From: Beverly Appleyard [REDACTED]
Sent: 22 January 2020 12:46
To: Amber Willard <Amber.Willard@arun.gov.uk>
Subject: The Ship Inn, Aldwick - OneStop Signage Application AW/337/19/A

As a local resident, I wish to voice my objections to the proposed OneStop Signage on what was The Ship Inn, Aldwick Street.

PROPOSED SITE SIGNAGE

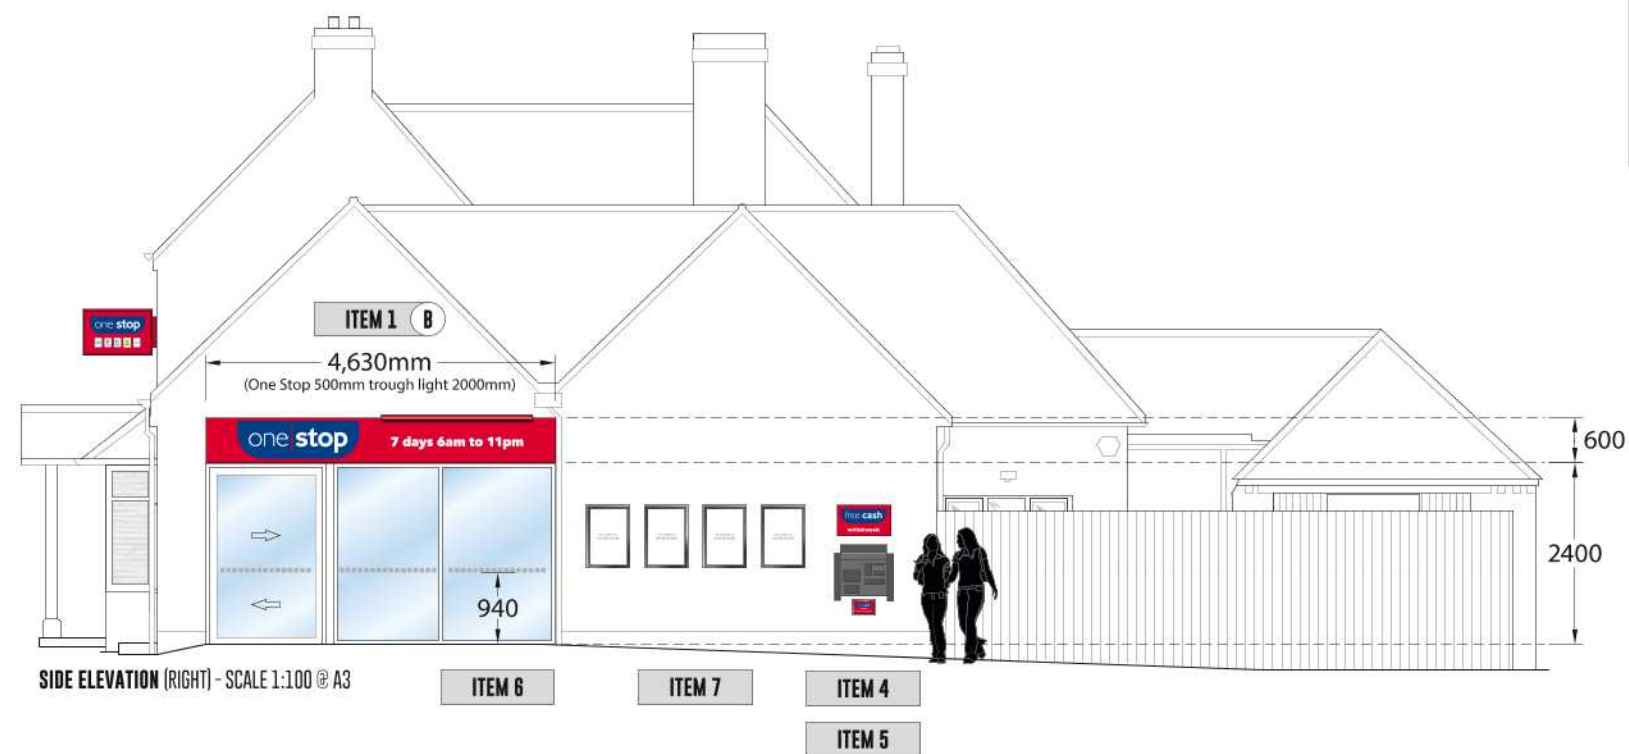
Their proposal is completely out of keeping with the area and especially on a building officially deemed of "special character". The proposed illuminated signage in the car park will have an undesirable effect on the adjoining flint wall of the Grade 2 Listed building. It's a further degrading of Aldwick as an urban village environment.

OneStop's proposed signage is too big, too bright and too garishly-coloured. Also, the application does not meet the degree to which outdoor lighting can be powered by on site renewable sources.

PROPOSED SITE SIGNAGE

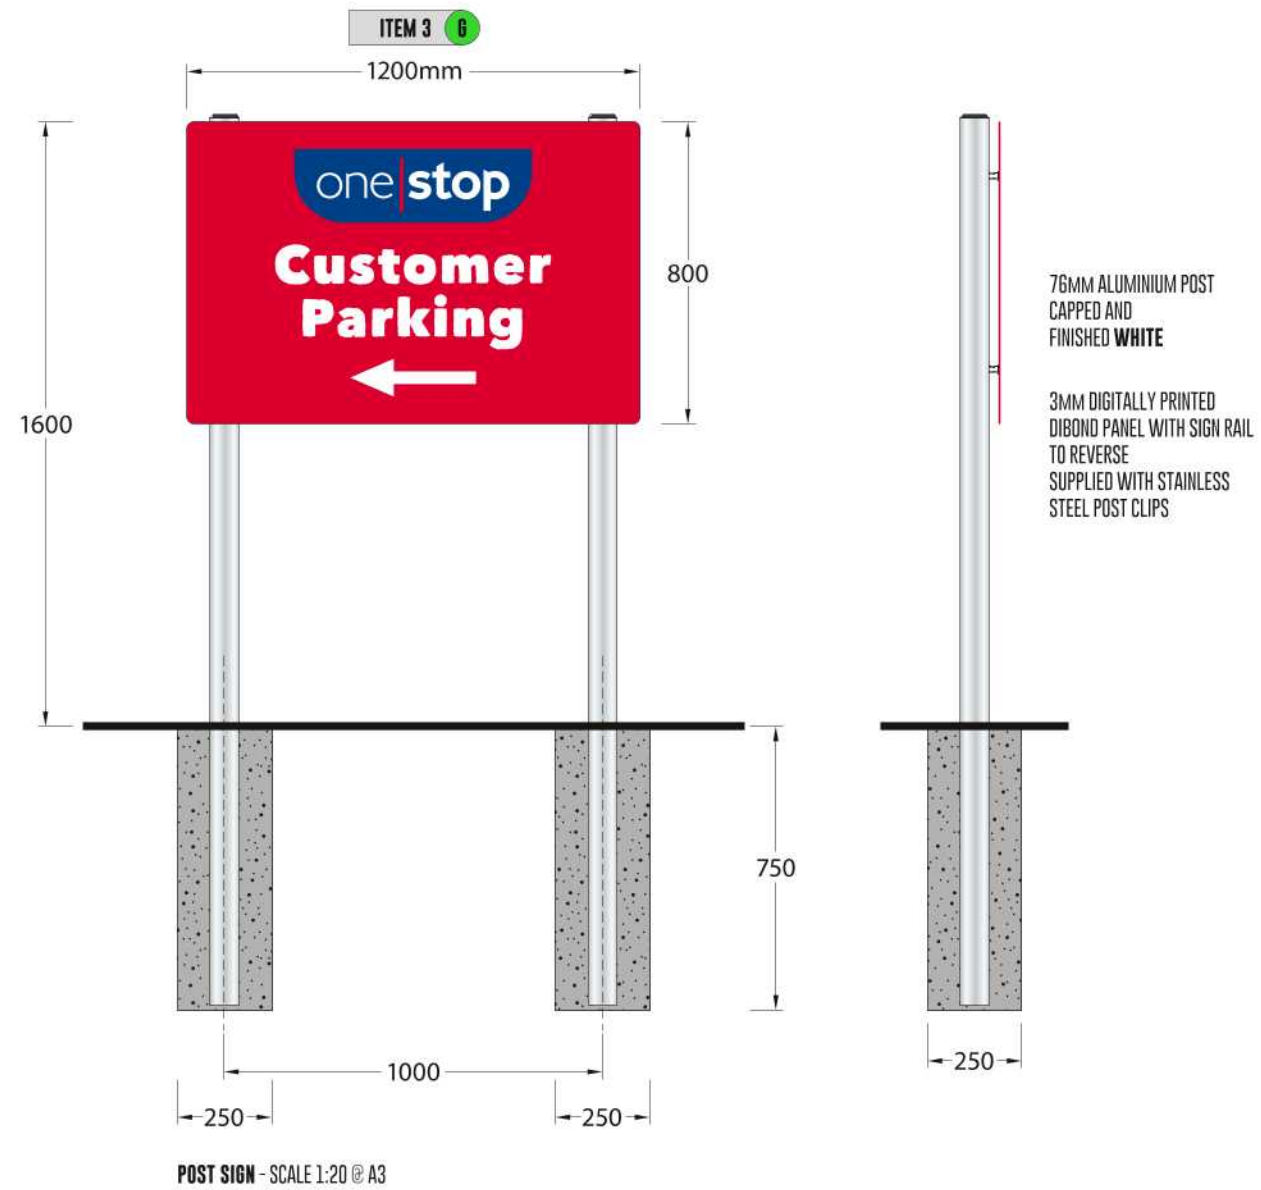
Also, OneStop's proposed window dressings are detrimental to this area of "special character".
